Moorebank Precinct East Stage 2 Proposal Response to Submissions

Appendix F: Supplementary Visual Impact Response to Submission Information

MEMORANDUM

ATTENTION CLAIRE VAHTRA
SENDER MICHAEL FASULLO
DATE 21/07/2017
PROJECT NUMBER 115123
SUBJECT MPE STAGE 2 RESPONSE TO SUBMISSIONS

view 04

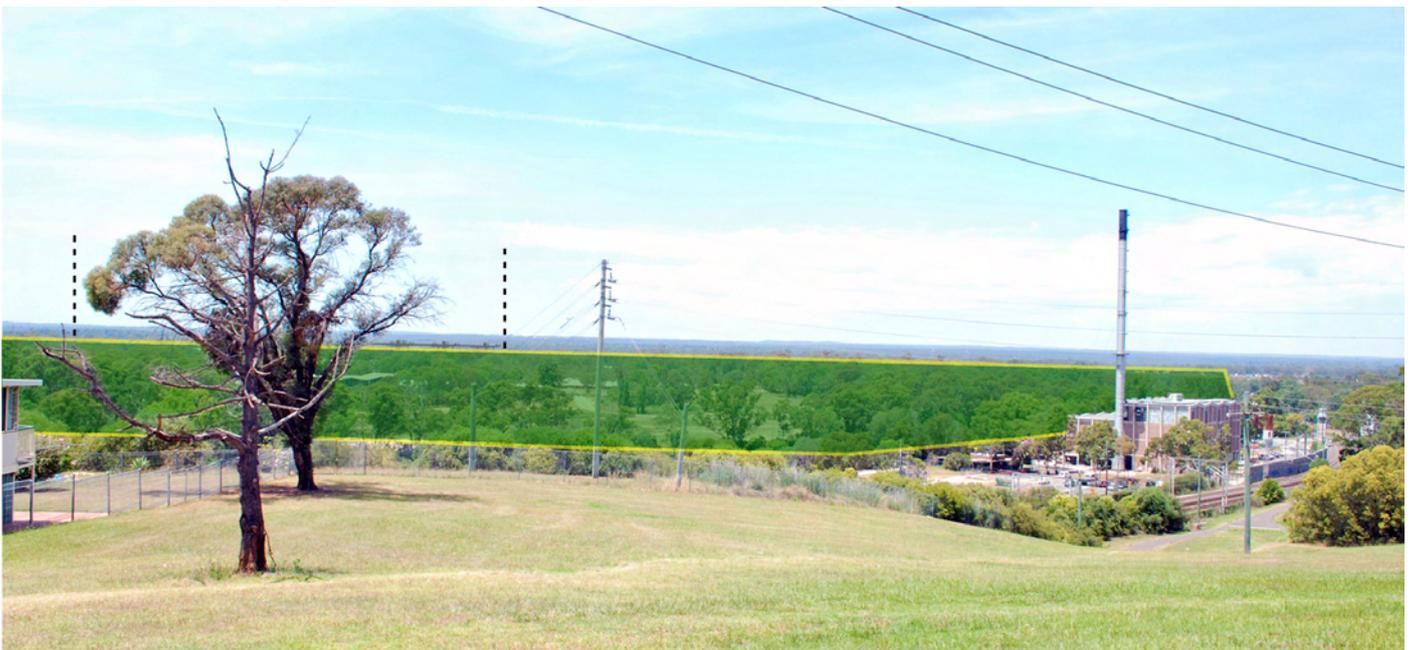
The perspectives created by viewpoints 04, 05 and 06 are misleading as they do not directly look at the works undertaken as part of MPE Stage 2. Viewpoints 04 and 05 are looking at the southern end of the MPE site and show the Stage 1 works but do not show the full extent of the development and therefore the full impact to the public from these two vantage points.

Viewpoints 04 and 05 are located in Casula Park and locations where a wide segment of the public would be exposed to the development.

Viewpoints 04 and 05 are inconsistent in their assessment of Visual Sensitivity. This criteria focused on the likely duration of views and number of observers from a given viewpoint. This criteria is independent of the 'prominence' of the Proposal. Viewpoints 04 and 05 are both located with Casula park but receive very different weightings for Visual sensitivity, with assessments of Moderate/High and Low respectively. If the viewpoint 05 assessment was amended to match viewpoint 04 for both the construction and operation stages of the project then Visual Impacts would change from Low to Moderate/High.

Viewpoints 04 and 05; located in Casula, as shown on Figure 8 of the EIS Visual Impact Assessment (VIA, Reid Campbell, 2016) are located west of the Proposal site and MPW site, in Casula. In response to the above issue raised by LCC, a revised assessment of the visual impacts of the Proposal at viewpoints 04 and 05 has been undertaken which show the extent of development across the Moorebank Precinct, inclusive of the Proposal, the MPE Stage 1 Project and the MPW Stage 2 Proposal.

The existing view from viewpoint 04 is shown on Figure 4, and the simulated view; with the Proposal, is shown on Figure 5. The existing view from viewpoint 05 is shown on Figure 6, and the simulated view; with the Proposal, is shown on Figure 7. The direction of view from this location is consistent with the viewpoints assessed in the MPE Concept EIS, and MPE Stage 1 Project EIS.

With regard to the comments made concerning the visual sensitivity applied to the assessment of viewpoints 04 and 05 (as included in Visual Impact Assessment at Appendix R of the EIS), Reid Campbell has reviewed and assessed previous findings to ensure accuracy and consistency. Findings in particular (as noted in a submission from Liverpool City Council) identified an inconsistency in the visual sensitivity of viewpoints 04 and 05 during the construction and operation phases of the Proposal. These inconsistencies have been tabulated below:

The inconsistency between findings for relatively similar viewpoints has been identified as an error in the initial report. To ensure accuracy both views were assessed against the criteria that defines how visual sensitivity is determined. Visual sensitivity for viewpoints 04 and 05 is therefore as follows:

*'Being a residential area the visual sensitivity would be relatively high. Several houses within the area and users of the park land would be able to see the development. This rating is lowered however due to the areas proximity to the site and its existing views of the industrial zoned land to the East, resulting in a **moderate** visual sensitivity.'*
